KITTITAS COUNTY

MEMORANDUM

TO: All Staff
FROM: Public Works Plan Review Team
DATE: August 19, 2024
SUBJECT: BL-24-00015 Gregersen

RECORD OF SURVEY FOR BOUNDARY LINE ADJUSTMENT

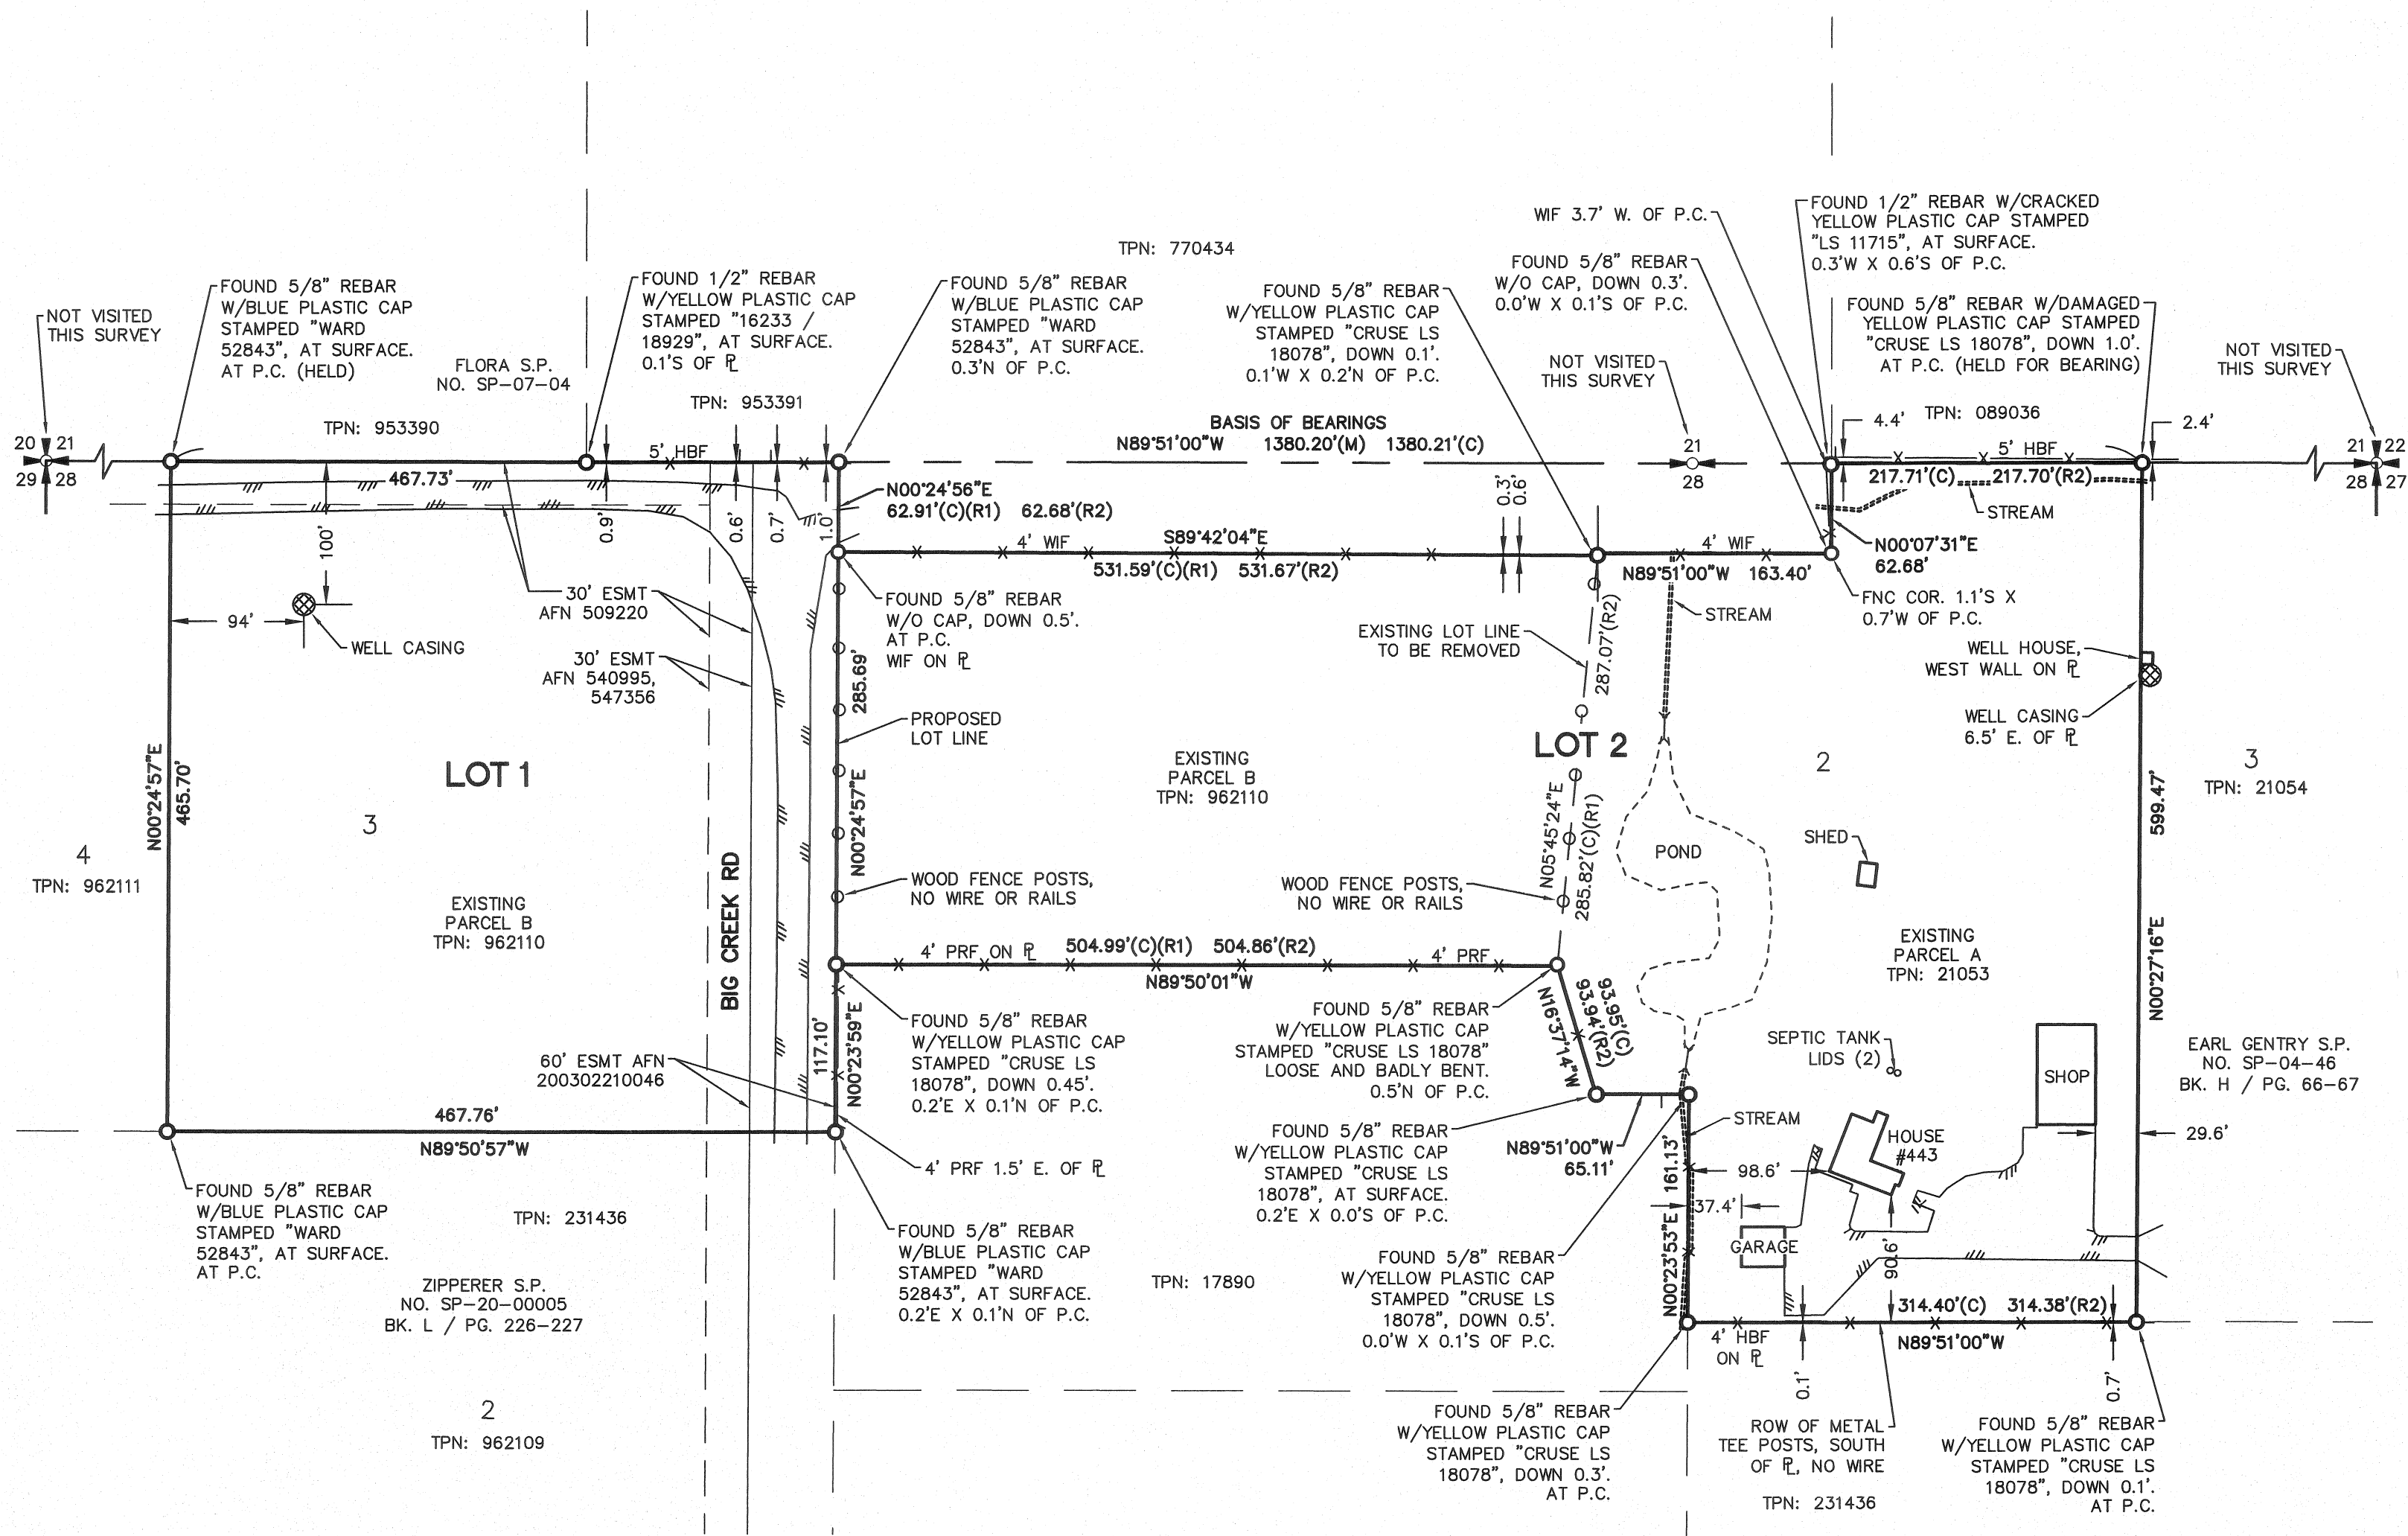
SURVEY	<ol style="list-style-type: none">1. Please include a "Purpose of Survey" note within Surveyors Notes, similar to the following: The purpose of this survey is to delineate parcels shown and to facilitate an application for Boundary Line Adjustment submitted separately to Kittitas County under Application BL-24-00015.2. Near NE Corner of Proposed Lot 1 there is a line with 2 reference distances shown (62.91(R1) 62.68(R2)). Please clarify which distance was utilized for retracement. Adding a (C) or (M) to the correct distance would be suitable.

<p>3. The W'most N boundary and W'most S boundary of proposed Lot 2 should include reference distances per (R2).</p> <p>4. The N boundary of proposed Lot 2 should show offset distances to the fence line position. Other fences appear to fall on the property line, but if this is not the case, offset distances to fence line shall be shown for those as well. (JT)</p> <p>OF NOTE Lot closures were not provided or reviewed as part of this survey review. Given the simplistic nature of the adjustment, closures are not required. (JT)</p>
TRANSPORTATION CONCURRENCY	No transportation concurrency requirements for this project. (KAH)
FLOOD	Parcels 21053 and 962110 and not within a FEMA identified special flood hazard area (100-year floodplain). (SC)
WATER MITIGATION/ METERING	No comments. (SC)
AIRPORT	No comments. (JS)
